PROPOSED REDEVELOPMENT OF COOP SMITHIES ACADEMY, HECKMONDWIKE – HIGHWAYS TECHNICAL NOTE 01 (4778) – NOVEMBER 2025

This Transport Note has been produced in response to the comments received from the local highways officers at Kirklees Council (KC), in their Consultation Response dated 29th October 2025 (Planning Ref: 2025/92598).

SWEPT PATH ANALYSIS - LOW LOADER - LEFT IN

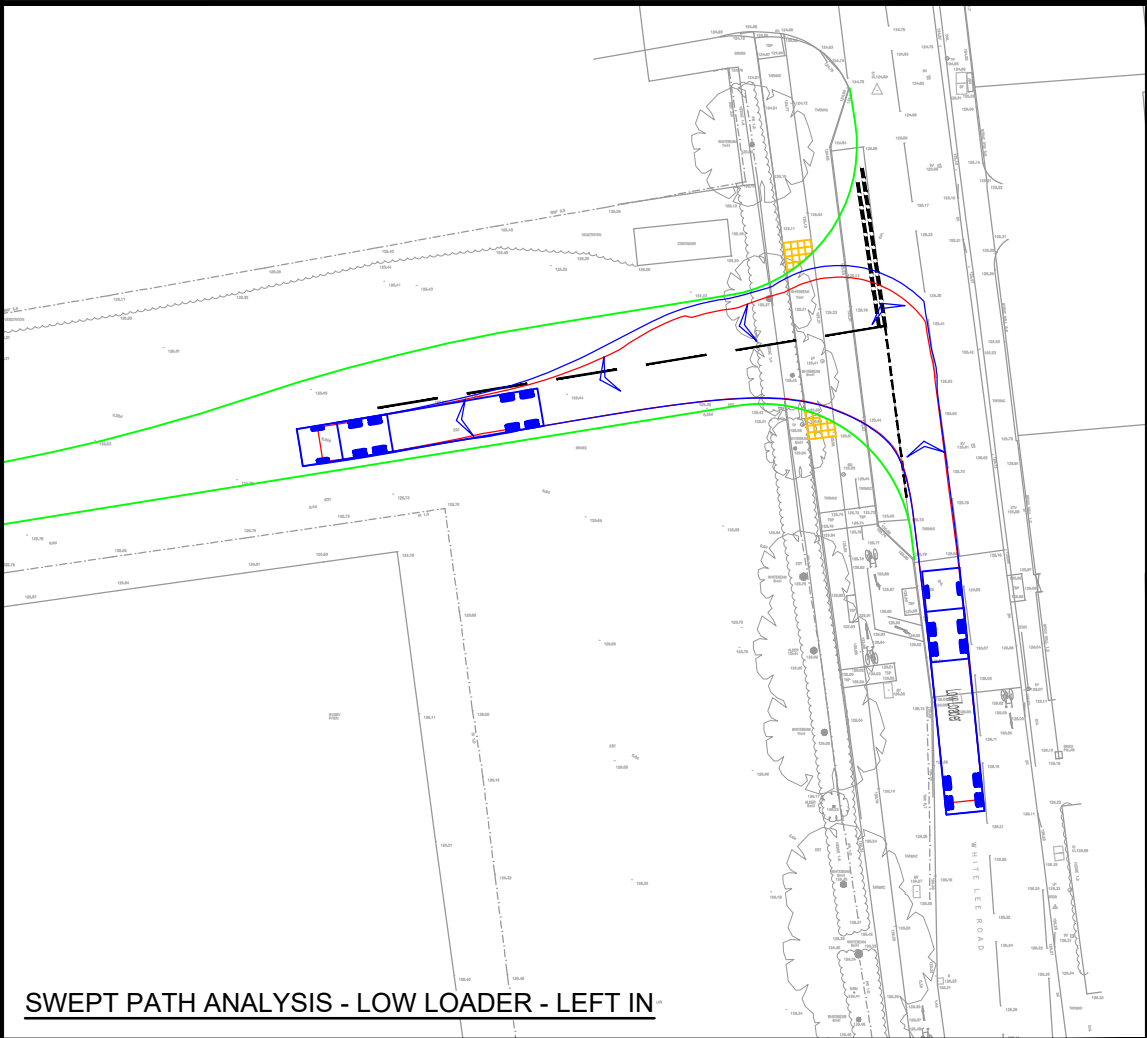
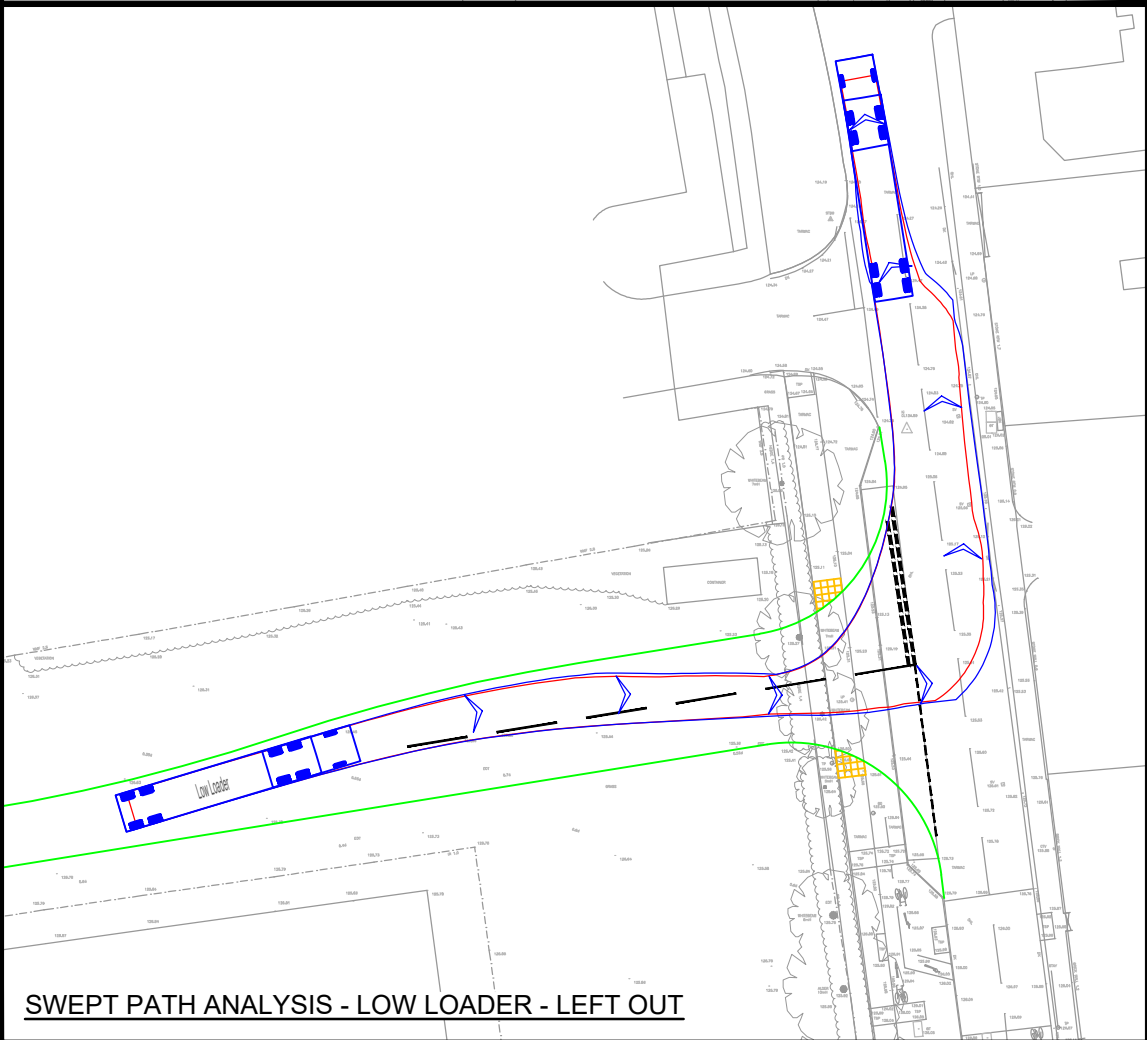
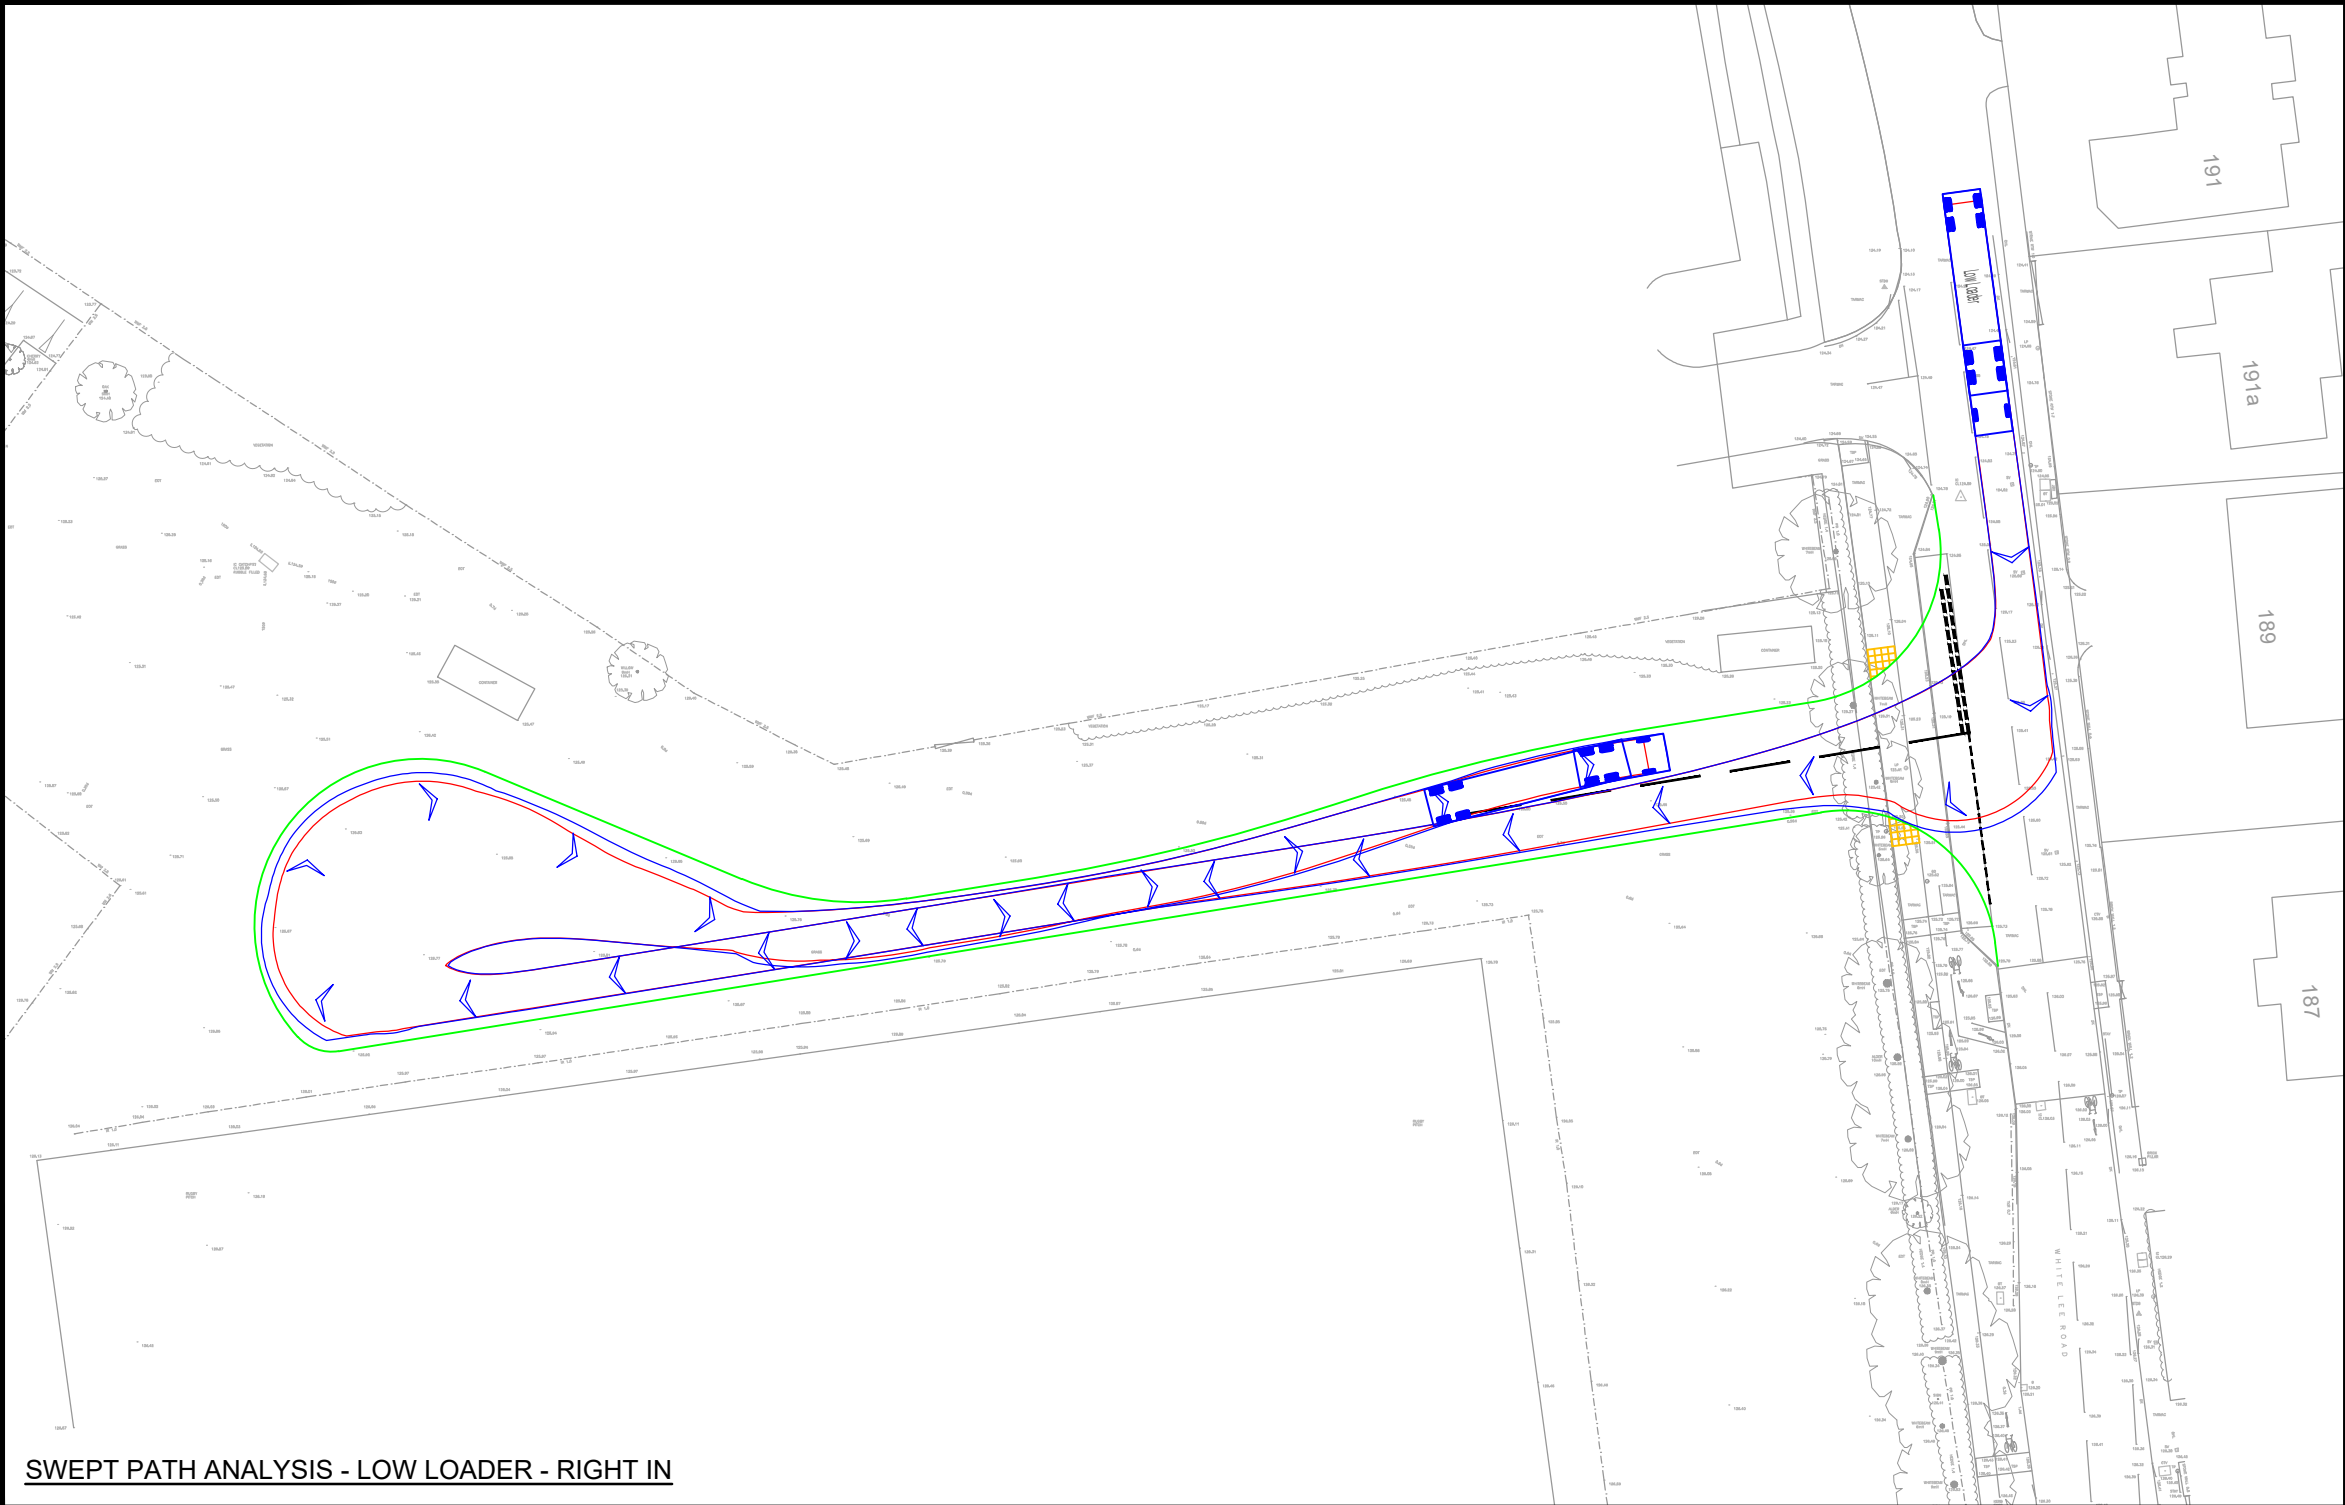
“HDM consider that the swept paths show that the access needs to be widened to allow comfortable turning and manoeuvre and access into and out of the site without crossing the Old Leeds Road centre line.”

Service vehicles will access and egress the site via Leeds Old Road, as they do at present there will be no changes to the servicing vehicle frequency or size as a result of the development proposals. Therefore, there are no requirements for any amendments to the existing access arrangement off Leeds Old Road.

With regard to the internal arrangements, the proposed internal arrangement is an improvement on the existing arrangement as a formal turning area is provided on site which will enable service vehicles to access and egress the site in a forward gear and not impact on the operation of the wider highway network.
